PREFERRED PROJECT REPORT

**LOT 104, 42 WALKER STREET, RHODES
(PRECINCT C)**

SEPTEMBER 2007

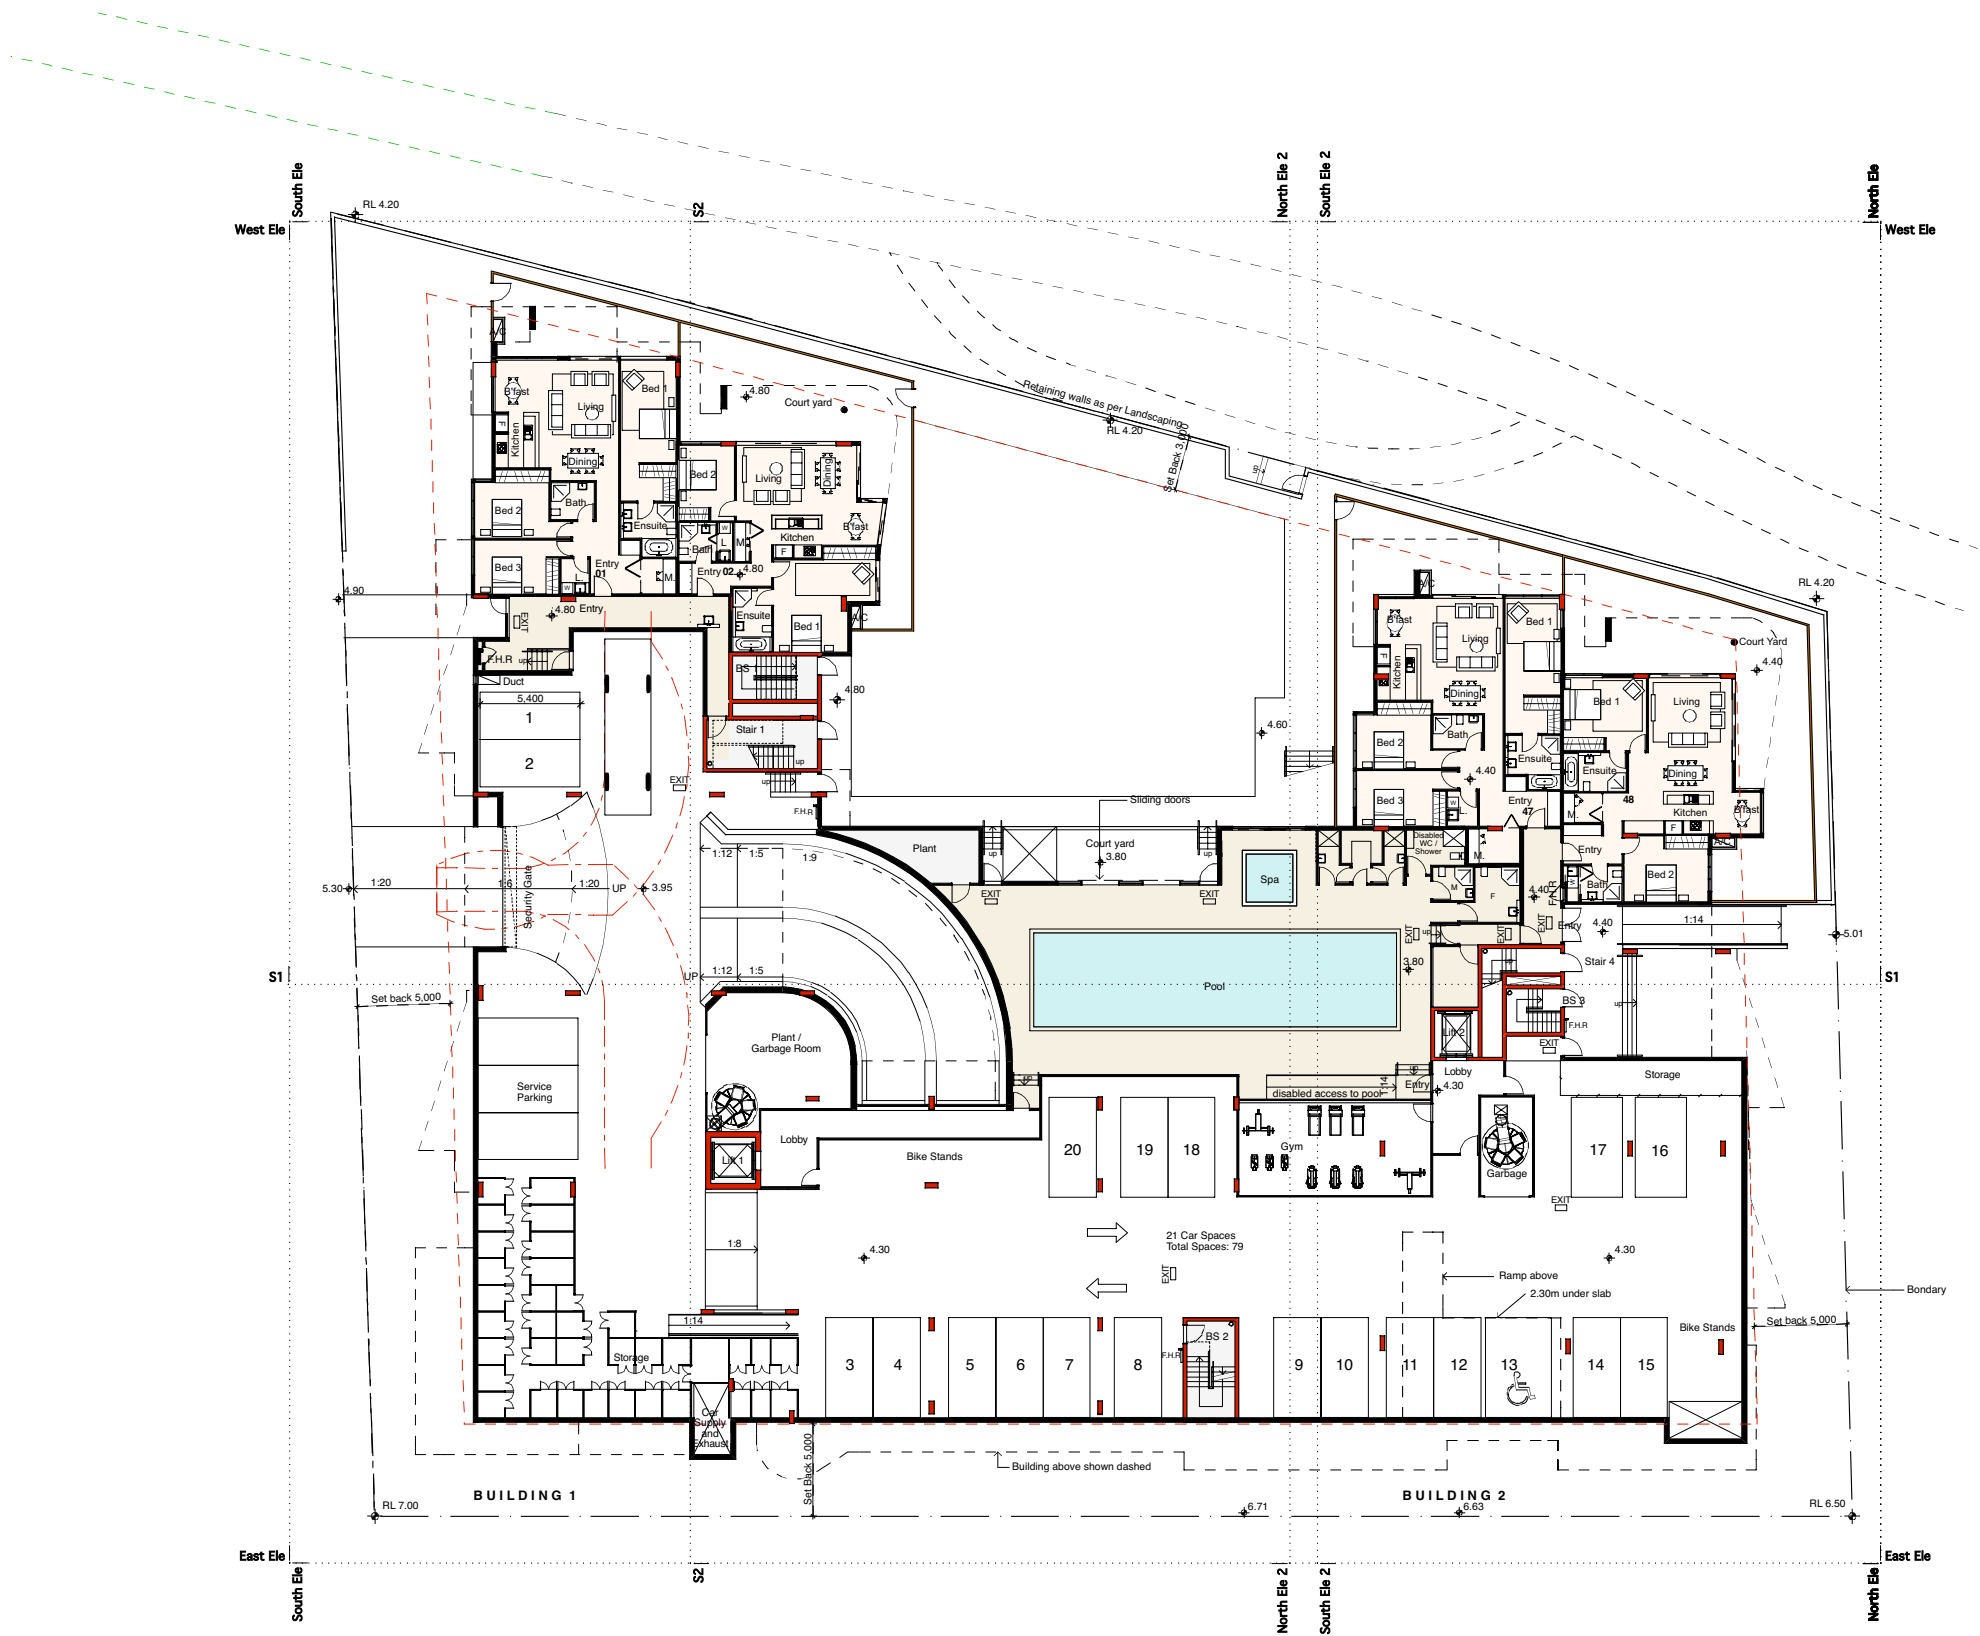
Ground Floor Units – There are no ground floor units with direct access to the street. The Renewing Rhodes DCP requires 50% of units to have direct access to the street.

All apartments on the lower ground level (drawing 06 DA) have individual access from the street. The proposal has been amended so that all units facing Shoreline Drive are directly accessible from the street. **Figure 2** below shows the access to Shoreline Avenue from street level apartments.

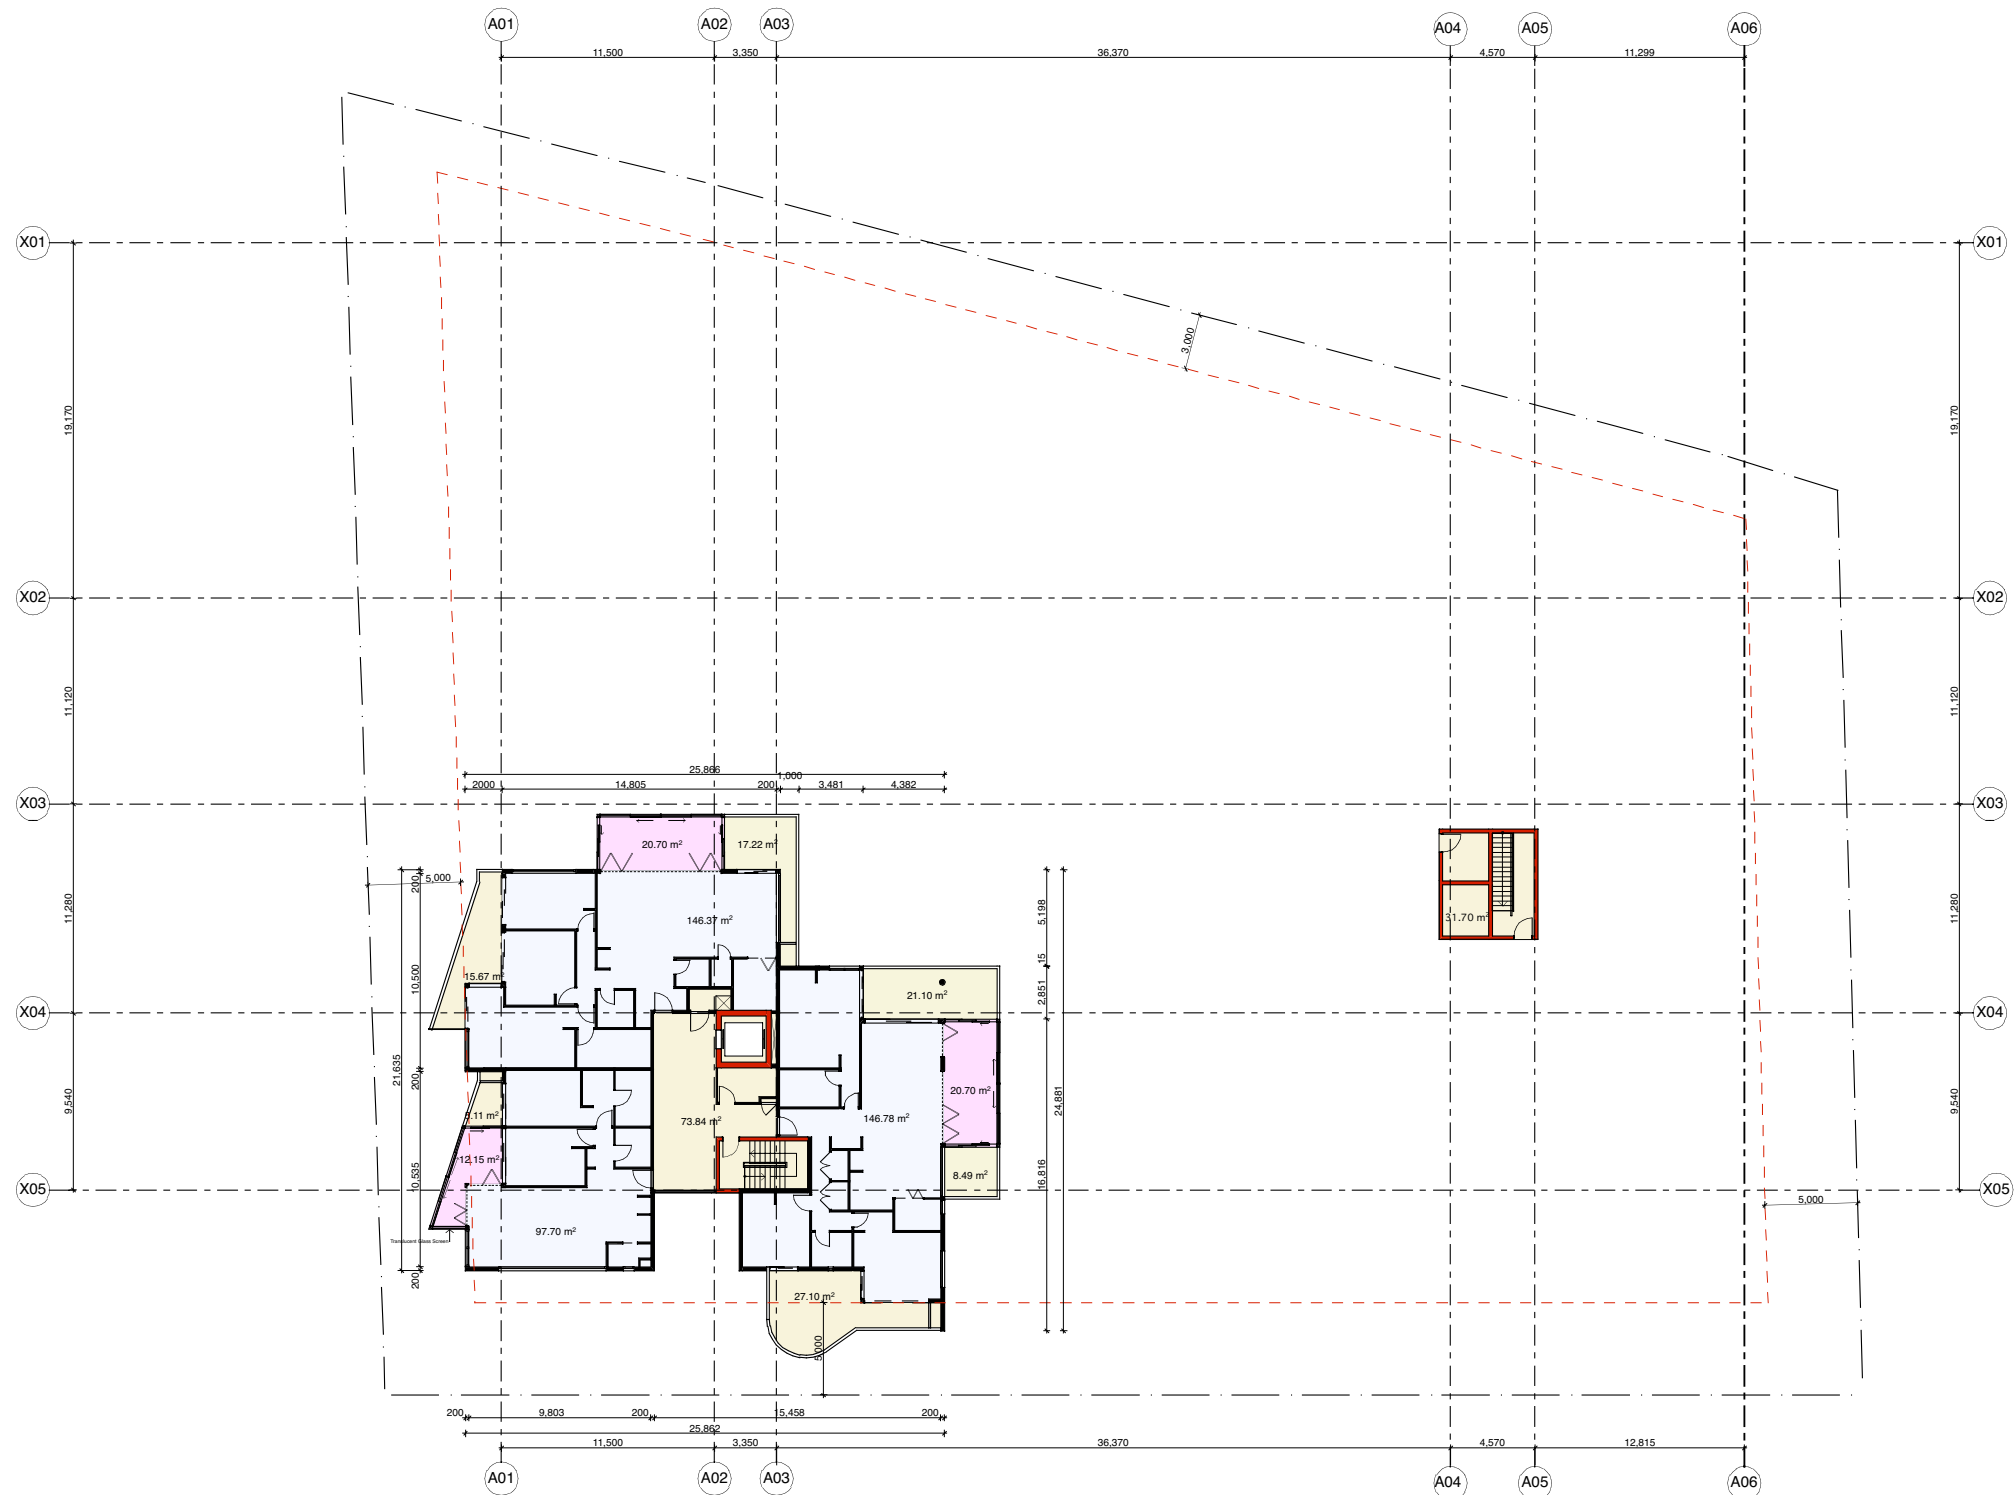
The fences along Shoreline Avenue have been amended to contain a solid, sandstone-clad base, 1.0 metre in height, with the upper part of the fence having louvres that will ensure passive surveillance and adequate privacy to the residents. Drawing 18 DA shows the amended fences.

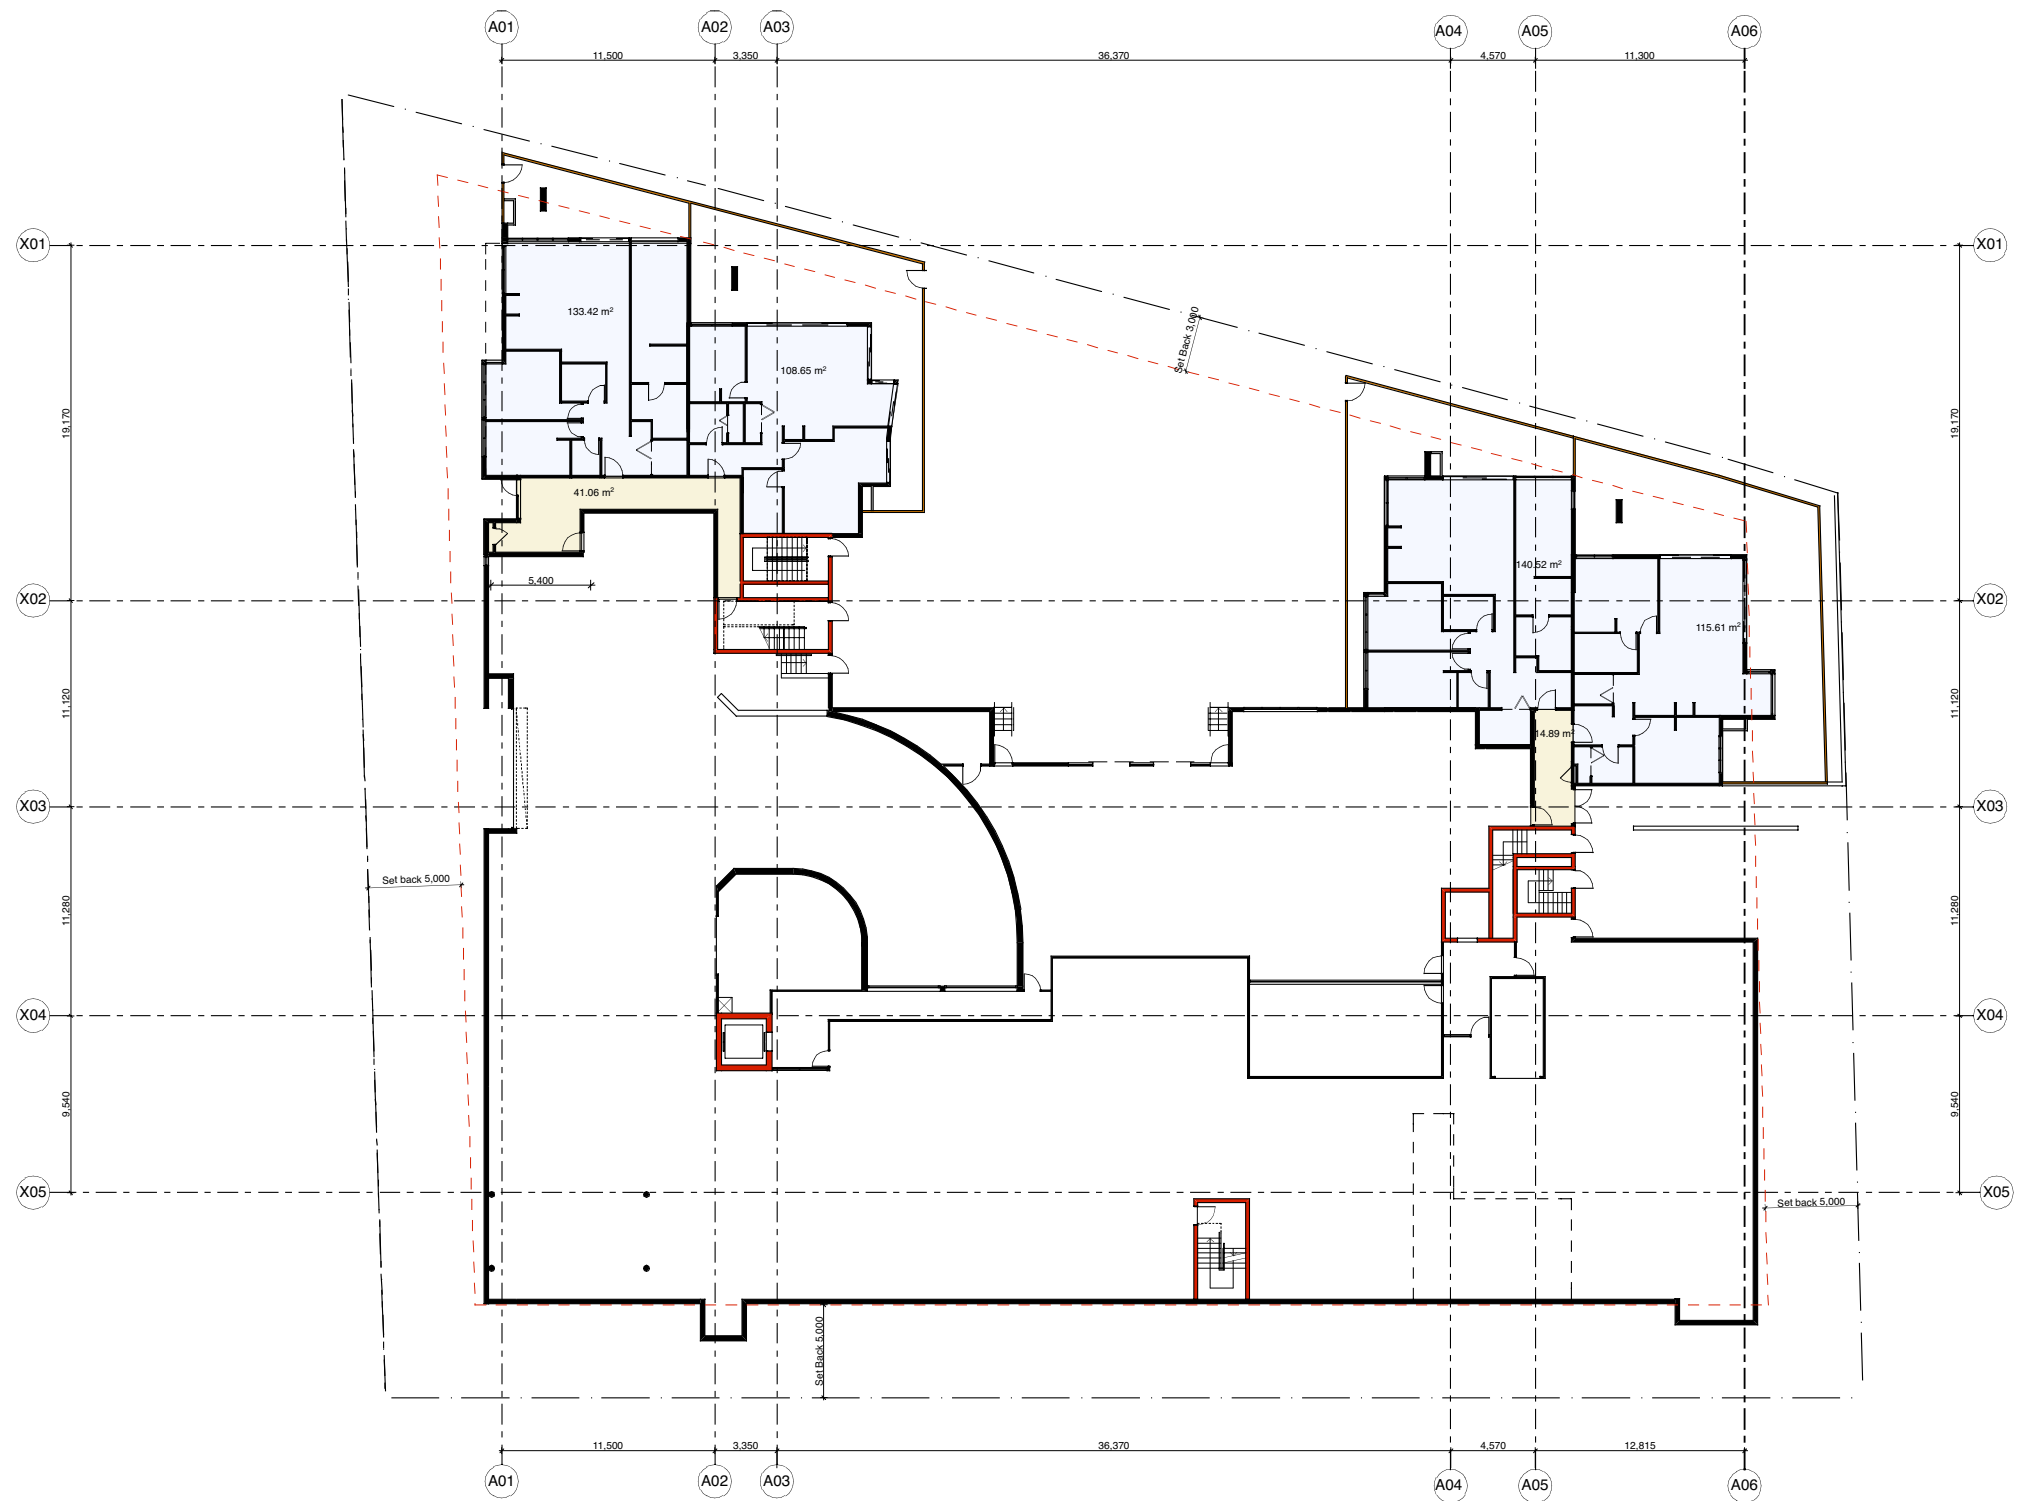
Section 5.4.2 of the RR DCP requires a maximum front fence height of 1.2 metres along Shoreline Avenue to allow visibility to entrances and allow for outlook and passive surveillance of Shoreline Avenue. The proposed fence height of 1.8 metres does not achieve the objectives of this requirement and the proposal is required to be amended to comply.

A 1.2-metre high fence does not provide adequate privacy to residents. Experience with ground floor units with inadequate fencing has seen residents putting up semi-temporary structures to provide needed privacy to their units. It is therefore appropriate to provide sustainable, architectural integrated fencing rather to provide temporary structures that cannot be regulated.

The amended design meets the DCP objectives of front gardens by defining the entrances to the courtyards and providing street surveillance combined with adequate privacy to residents.

SECTION 1 BUILDING 1

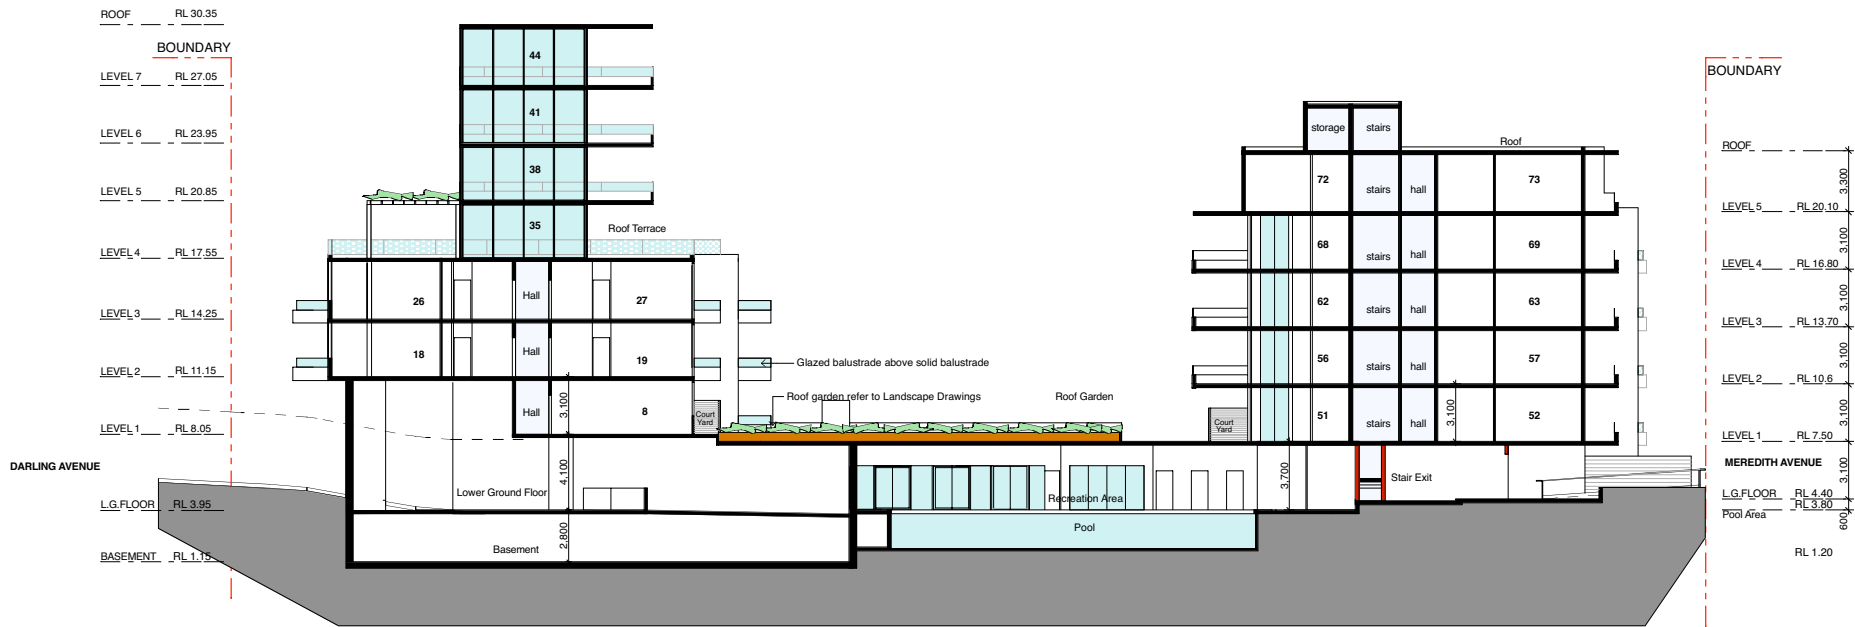
Height – the proposal appears to breach the height control of the Concept Plan. A portion of Building 2 appears to be 6 stories in height and located within the 5-storey maximum height zone. A Section through this part of the building is required to be provided to accurately demonstrate the height of the building. All non-compliances with the Concept Plan are required to be addressed.

Building 2 has been amended to comply with the 5-storey height limit imposed by the concept plan. **Figure 1** is a Section of the amended Building 2 that shows compliance with the height limit, in that no section of the basement level rises more than 1.5 metres above finished ground level. The Section diagram is located on drawing No. 19 DA.
